CAVERSFIELD PARISH COUNCIL

Caversfield Parish Council met on 28 August and considered planning application reference 19/01271/F at The Bothy, Brashfield House, Buckingham Road, OX27 8RE for "Sub-division of existing dwelling into 2no. 4 bedroom houses including new ground & first floor extensions. Demolition of existing garden wall. Erection of 2no. double garages with ancillary spaces. Creation of a new vehicular access to serve both houses. New hard and soft landscaping proposals".

The Parish Council objects to the proposals on the following grounds.

Drawing:
 PLOT 1 – PROPOSED ELEVATIONS

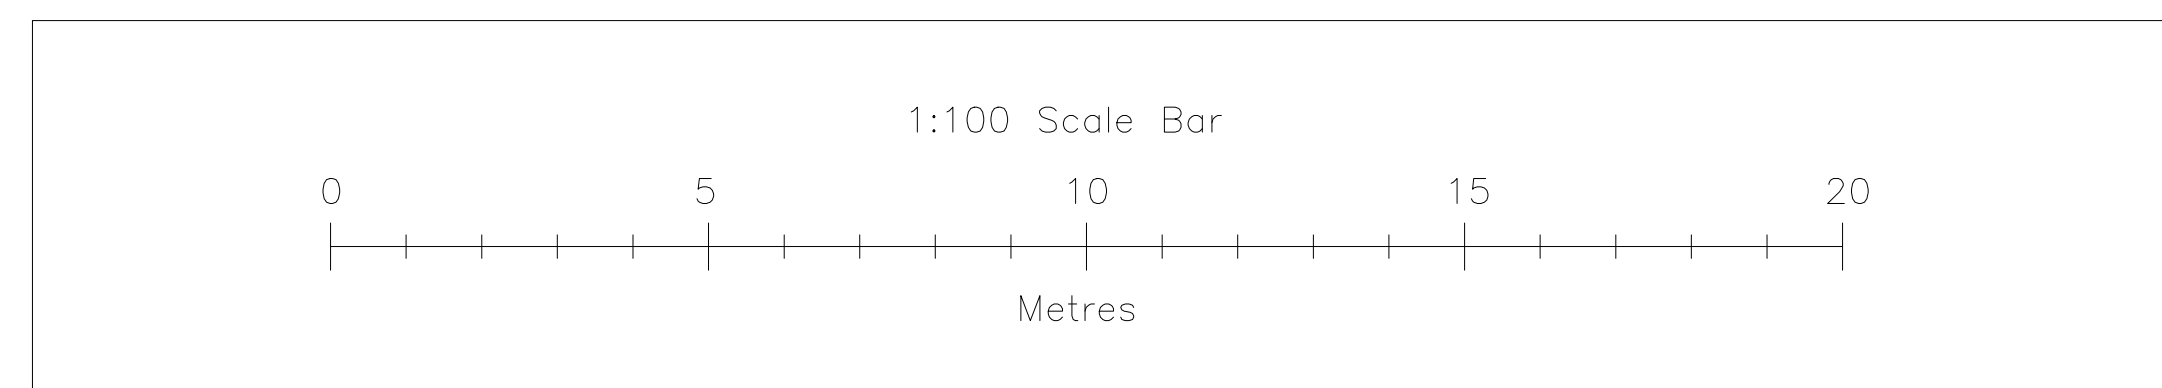
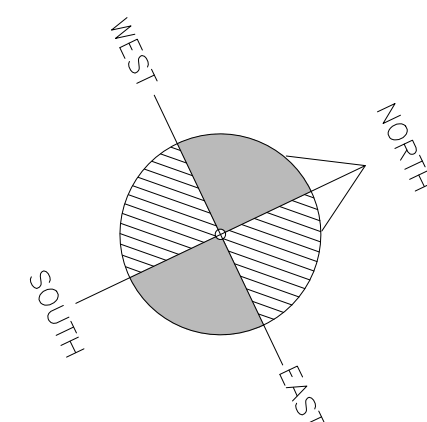
The height of both the main properties at two stories is overbearing and the garages at over 4m high are inappropriate for the area. The design and number of the windows and doors significantly changes the character of the buildings.

Drawing:  
**PROPOSED BLOCK PLAN**

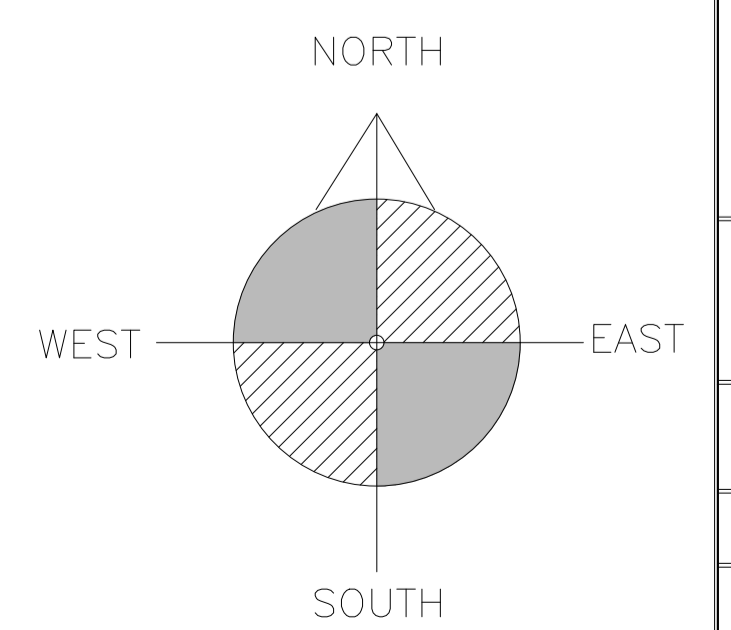
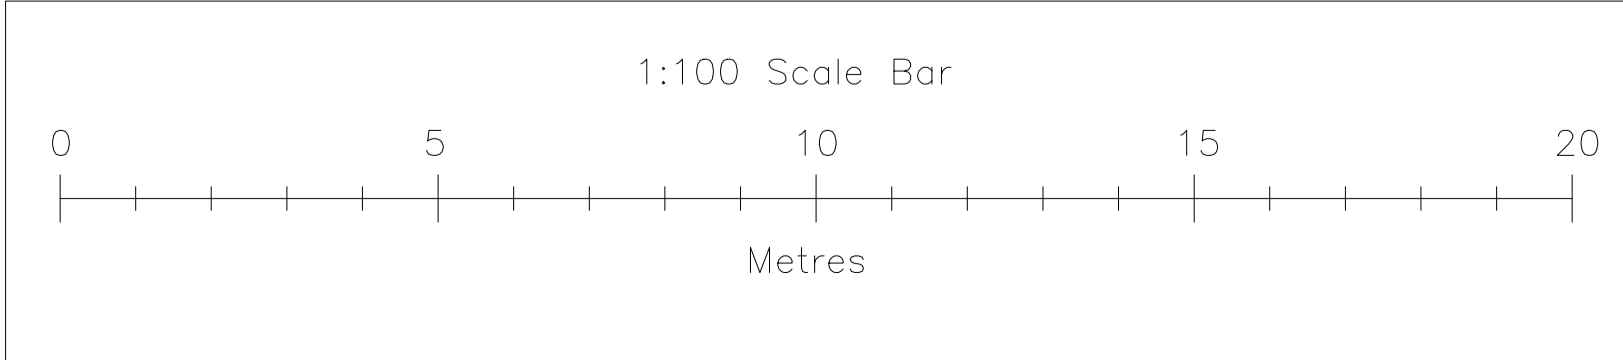
The access driveway is very narrow in parts and it is not possible to widen this at the narrowest part as it would encroach on one of the other properties. While the driveway is acceptable for the single house, it would not be suitable for the additional traffic of a second house.
